18 November 2025

SUBJECT: Mod 8 - Ulan West Continued Operations (MP08_0184-Mod-8)

Thank you for providing Mid-Western Regional Council with the opportunity to review Mod 8 - Ulan West Continued Operations documents associated with Ulan Mine.

Figure 6: Proposed Modification 4 assessment area showing extent of previous heritage survey coverage to current standards (aerial photograph courtesy UCML; one kilometre MGA grid).

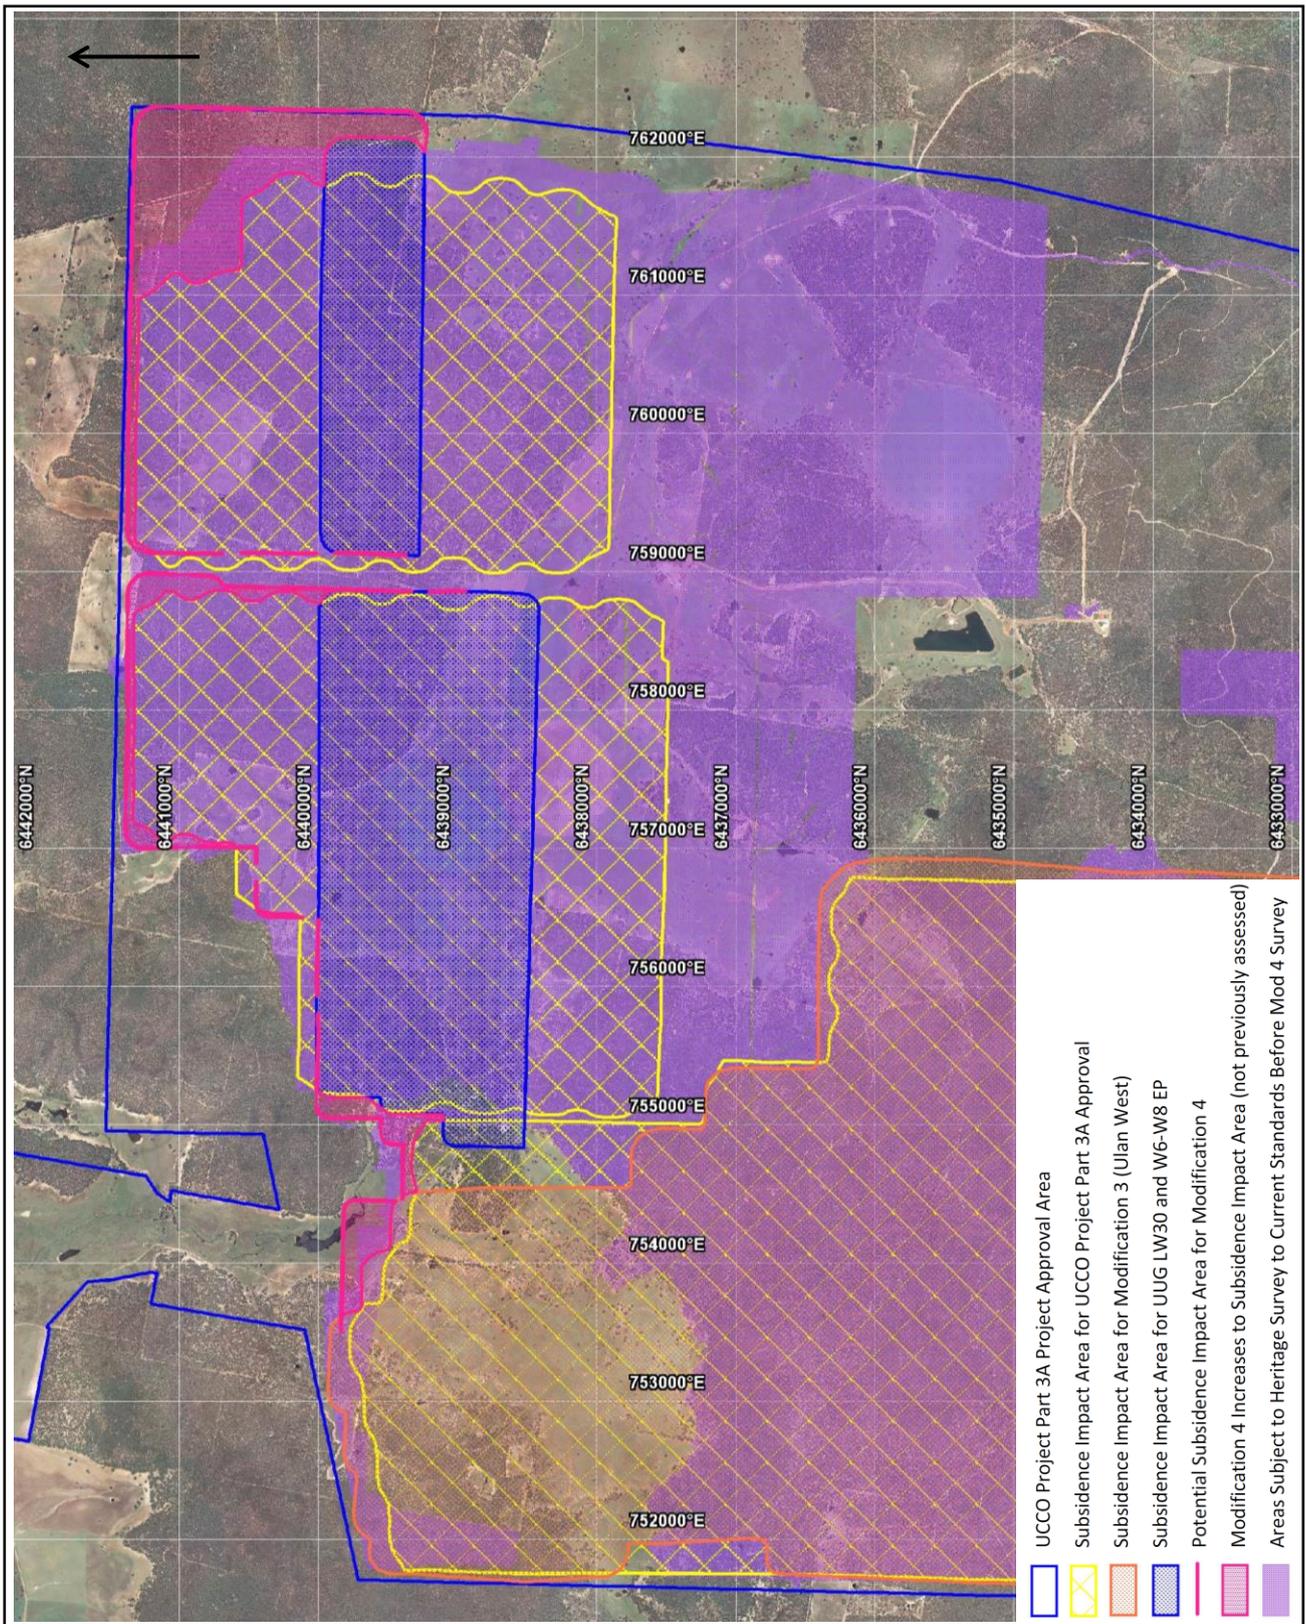
Figure 6-1 identifies a portion of the approved area that was not assessed due to inaccessibility. To ensure the accuracy and completeness of the assessment, the entire area proposed for disturbance should be assessed under the AHIP process. The report does not provide an explanation for why this area was inaccessible to archaeologists; however, as noted within the report, it is highly likely or possible that additional artefacts or sites of cultural significance may be present within this unassessed area.
